**Date:** May 24, 2022  
**To:** Jeremy Cromie, County Planner II  
**From:** Craig Jones, City Development Coordinator *CJ*  
**Through:** Derek Mayo, City Engineer *DM*  
**Re:** Calvary Church Expansion – CU-22-00002

The following are the City Public Works comments on the Conditional Use for the proposed Calvary Church Expansion at Vantage Hwy and Cowboy Ln.

CITY OF ELLENSBURG  
 PUBLIC WORKS DEPARTMENT  
 UTILITY MAP REQUEST INFORMATION

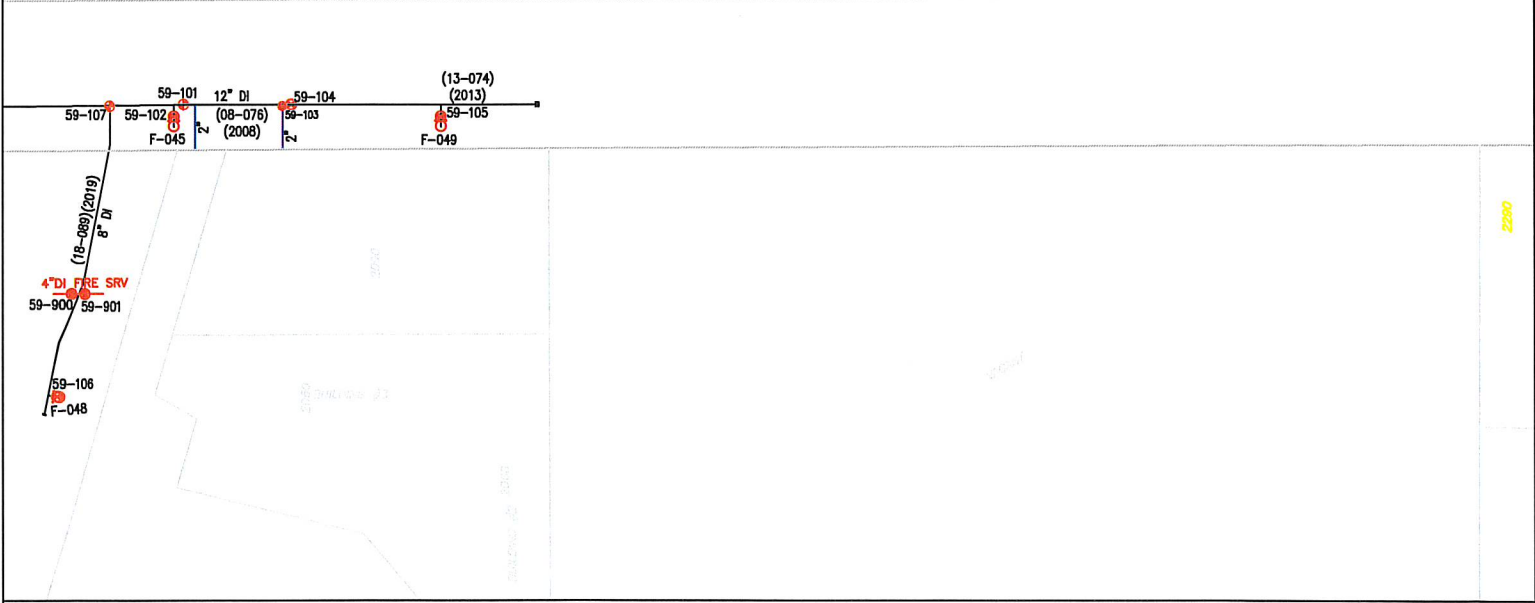
The water main available to serve this development is a 12" Ductile Iron main that runs in Vantage Hwy and stops approximately 680'+/- from the proposed project. The developer will need to extend the main to the farthest east extents of the property being developed along Vantage Hwy. The existing buildings on site will need to connect to City water. See attached utility map.

CITY OF ELLENSBURG  
 PUBLIC WORKS DEPARTMENT  
 UTILITY MAP REQUEST INFORMATION

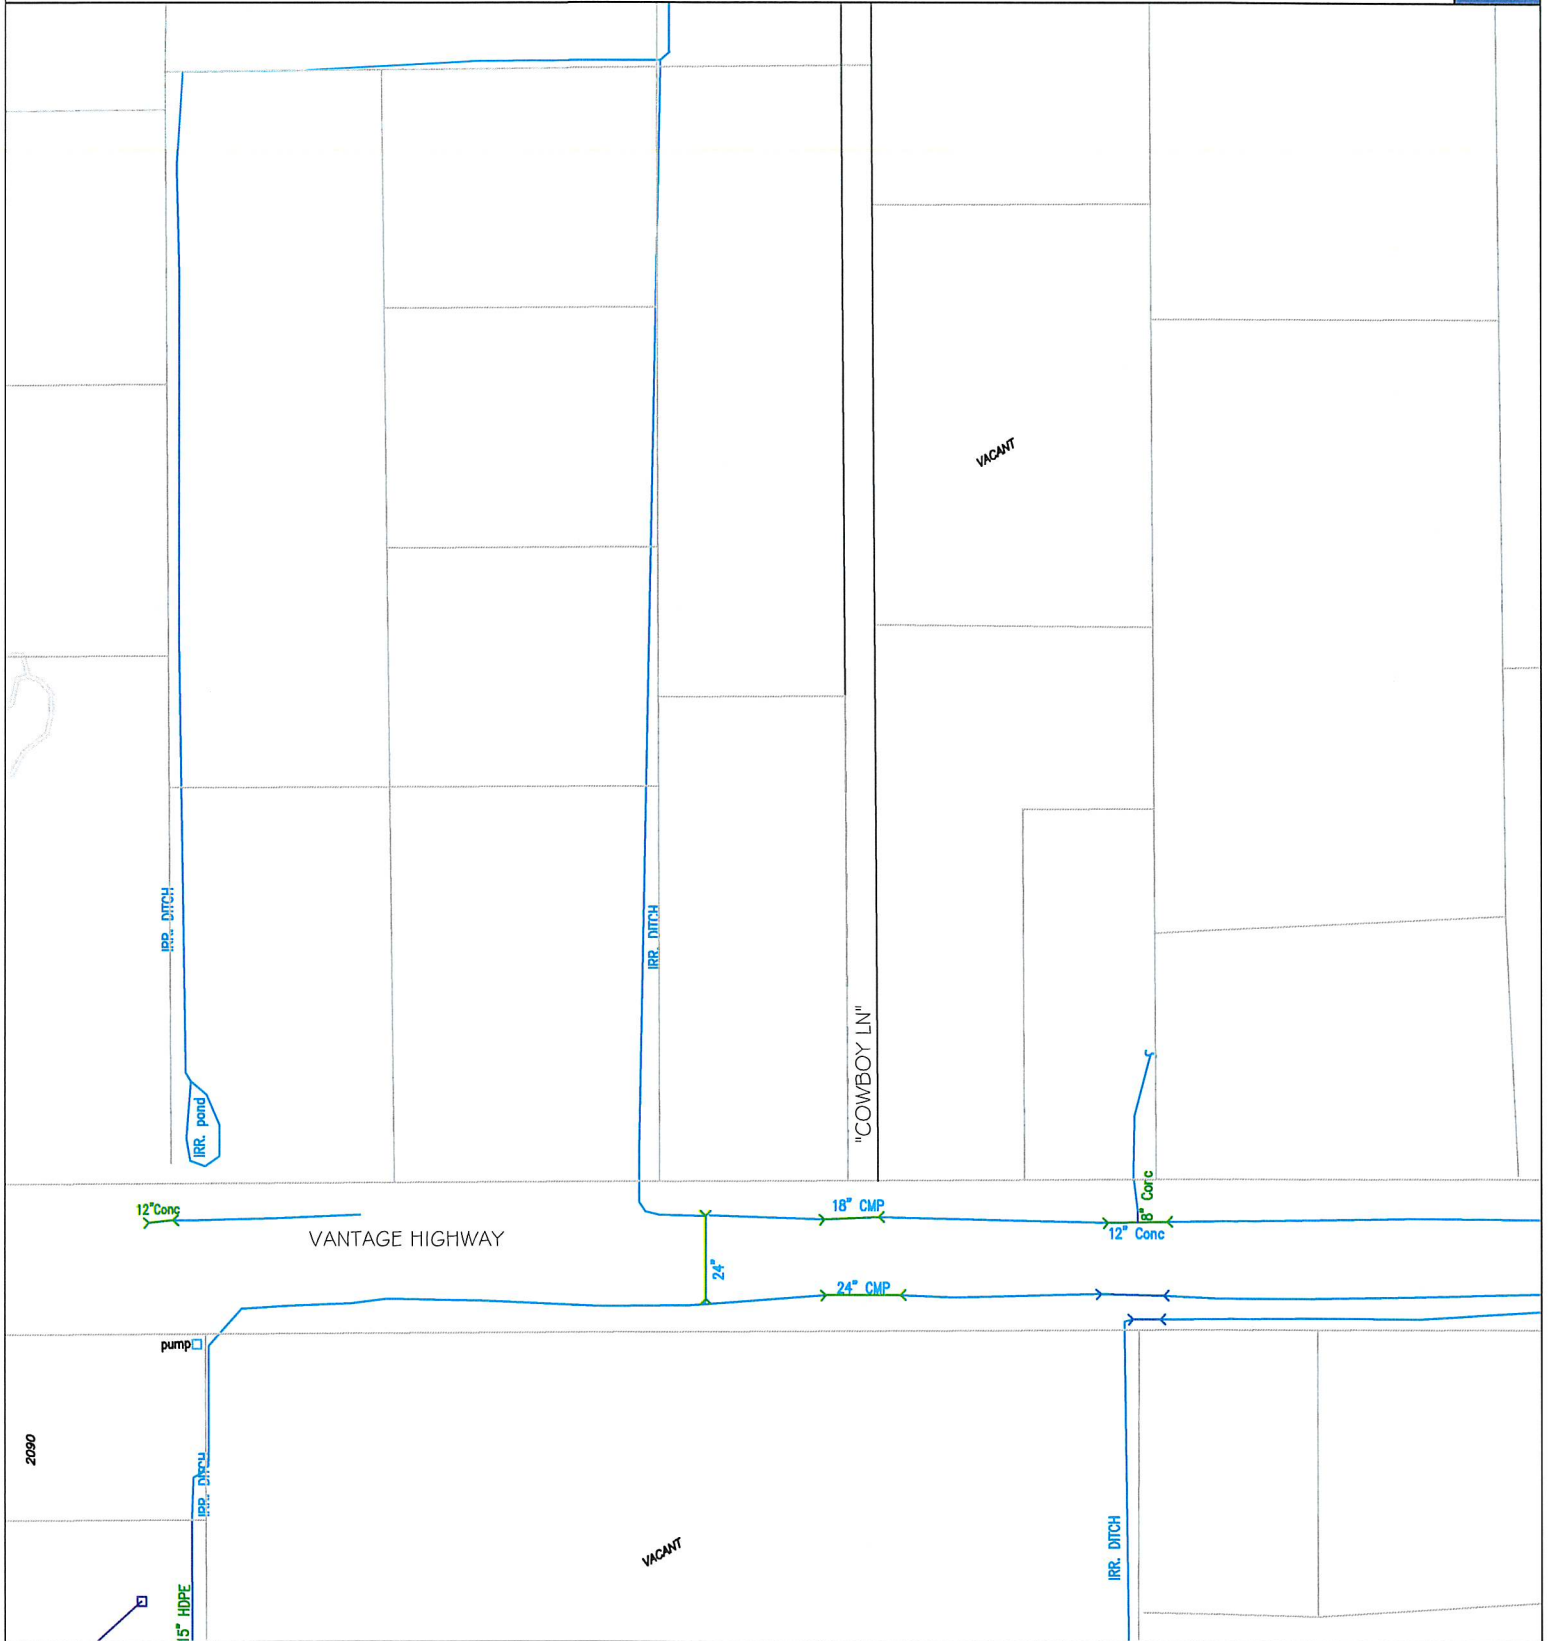
The sewer main available to serve this development is a 12" PVC main that runs in Vantage Hwy and stops the same location as water. The developer will need to extend the sewer main to the farthest east extents of the property being developed. The existing buildings on site are served by an onsite septic system that will need to be abandoned and connected to City. See attached utility map.

There is a drainage ditch along the south side of the parcel. Stormwater outfall could be discharged here after on site treatment and flow control were met. See attached utility map.
